App: BR/265/21/DOC

Proposal: Approval of details reserved by condition imposed under BR/222/21/PL relating to conditions 4-covered and secure cycle parking spaces, 5-highest available headline speed of broadband & 6-replacement of two bird boxes on building.

Address: Vincent House 75 Highfield Road Bognor Regis PO22 8PD

Vincent House, 75 Highfield Road, Bognor Regis. PO22 8PD
Release of conditions 4,5 & 6 for planning ref: BR/222/21/PL
Drawing no. 1

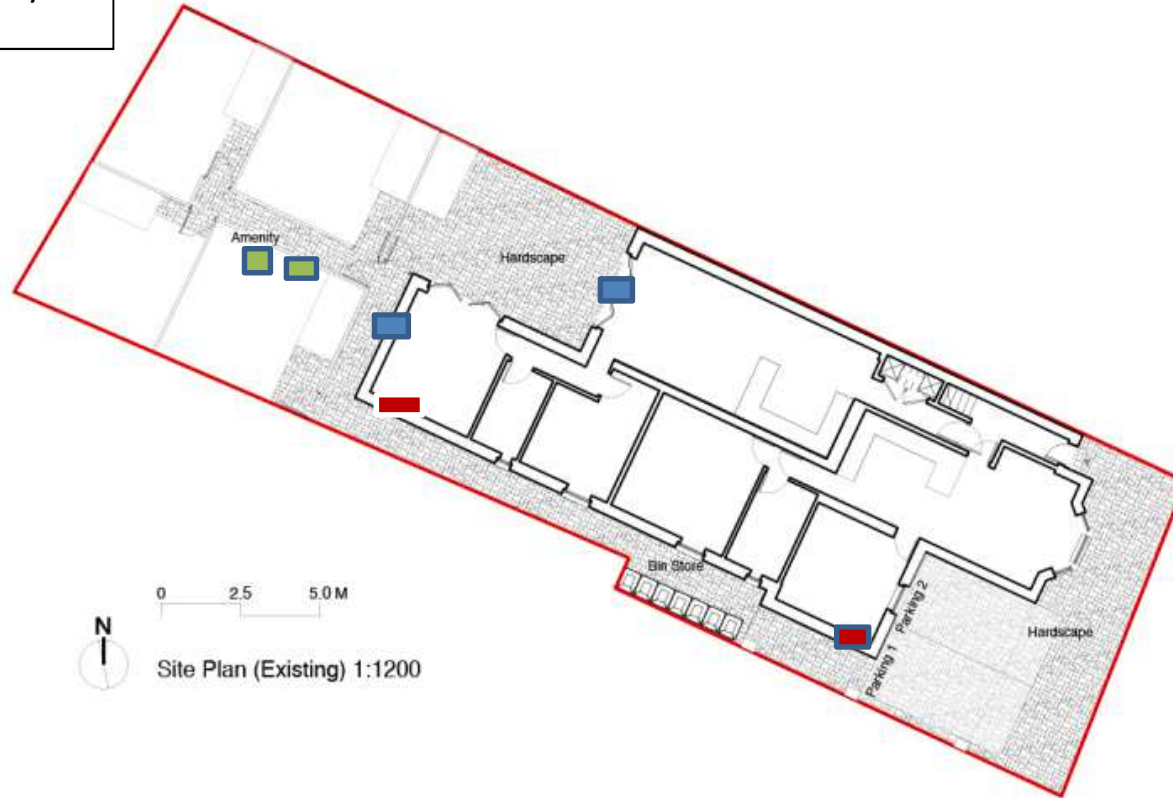
The location of the two bird boxes is satisfactory and this condition can now be discharged.
